# **KITTITAS COUNTY**

### **MEMORANDUM**

**TO:** All Staff  
**FROM:** Public Works Plan Review Team  
**DATE:** July 1, 2024  
**SUBJECT:** SD-24-00001 & CU-24-00005 Red's Fly Shop

SITE PLAN

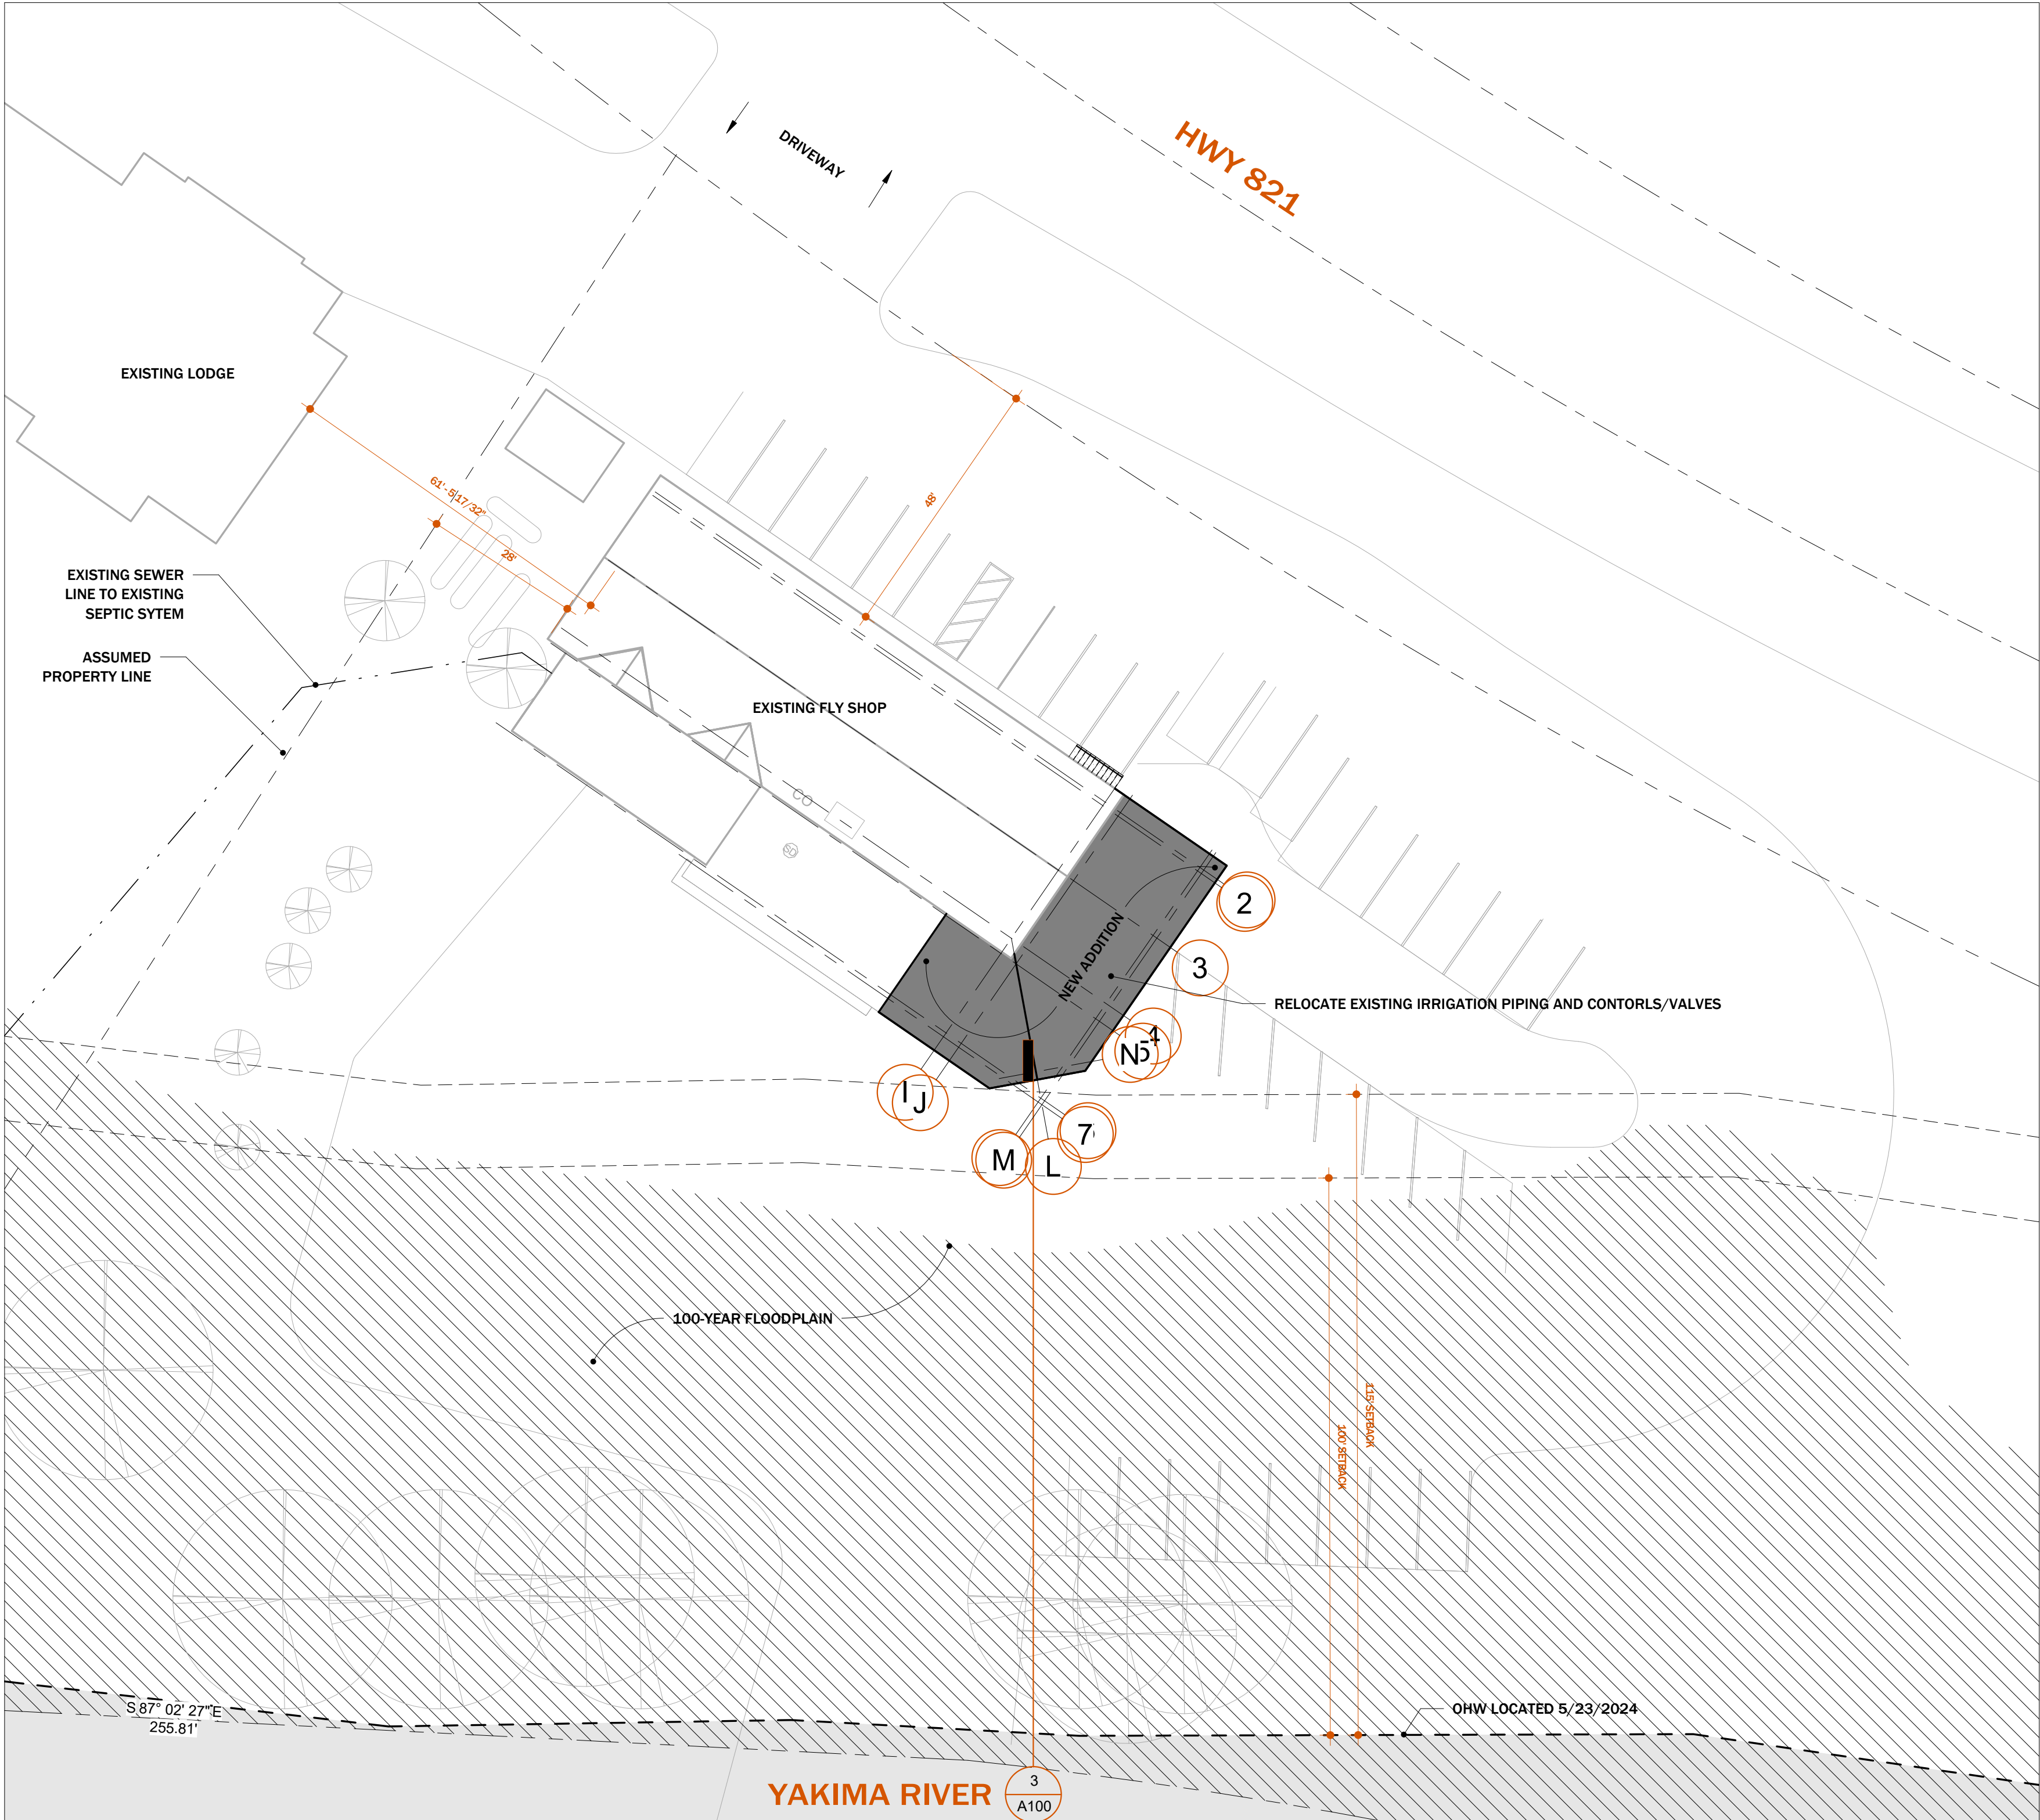
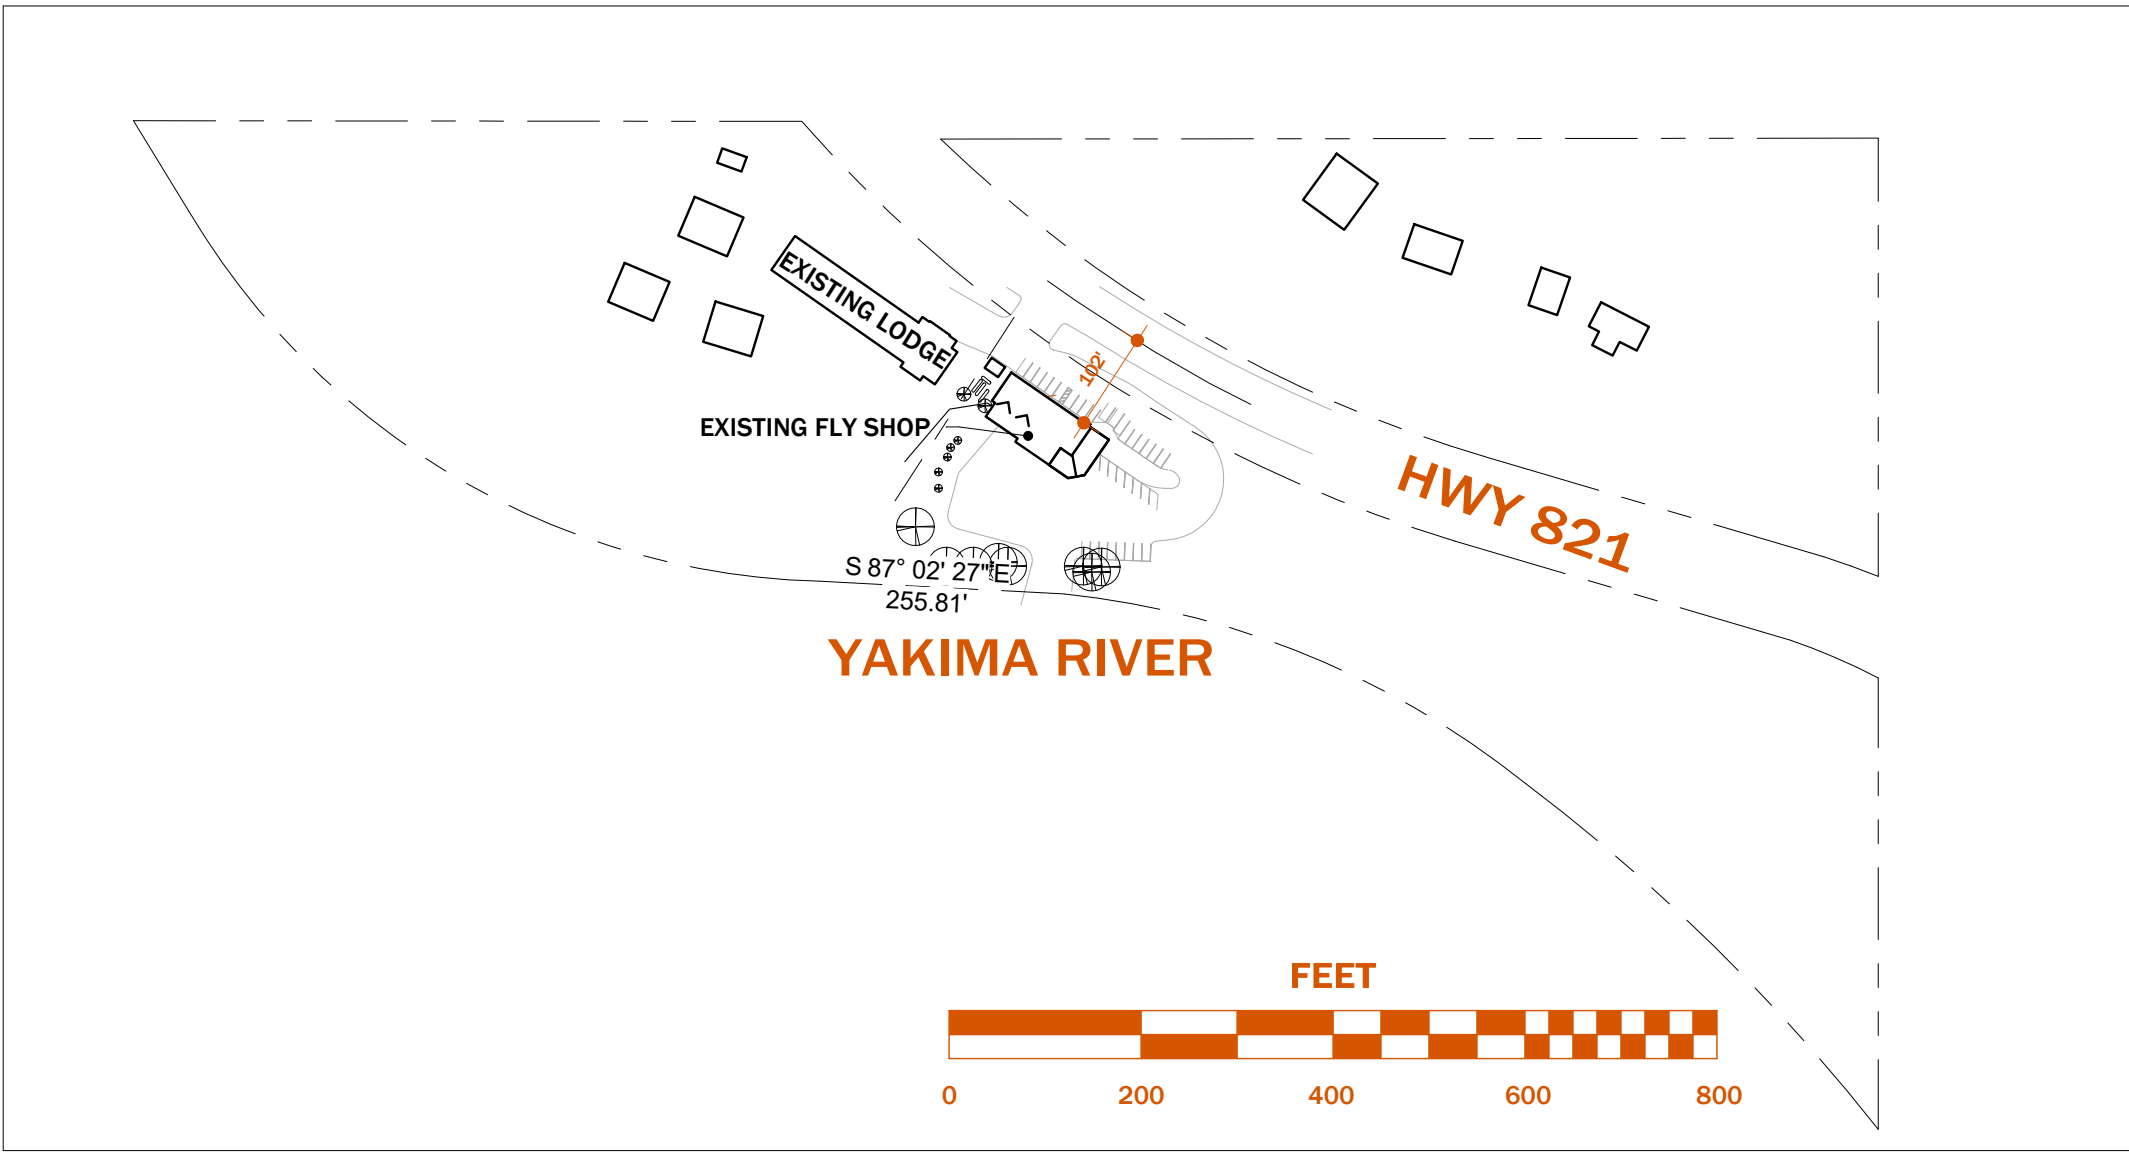
<b>ACCESS</b>	Existing access will be used. No additional access comments. (JS)
<b>ENGINEERING</b>	Except as exempted in KCC 14.05.060, no grading or filling upon a site involving more than one hundred (100) cubic yards shall be performed without a grading permit from the County Engineer or Public Works designee (KCC 14.05.050). An application for grading in excess of five hundred (500) cubic yards shall be accompanied by an engineered grading plan (KCC 14.05.080). (CP)
<b>SURVEY</b>	No survey provided, no comments (KH)
<b>TRANSPORTATION CONCURRENCY</b>	No transportation concurrency application is required for this project. (KAH)
<b>FLOOD</b>	<p>A portion of this property is within the 100-year floodplain. Since the proposed activity is outside the 100-year floodplain a floodplain development permit will not be required.</p> <p>If possible, any future development should also remain outside of the floodplain in order to reduce risk and avoid mandatory flood insurance purchase requirements. All activities within the floodplain must be permitted through the floodplain development permit process and follow the regulations within KCC 14.08.</p> <p>Please include the floodplain boundary on the site plan. (SC)</p>
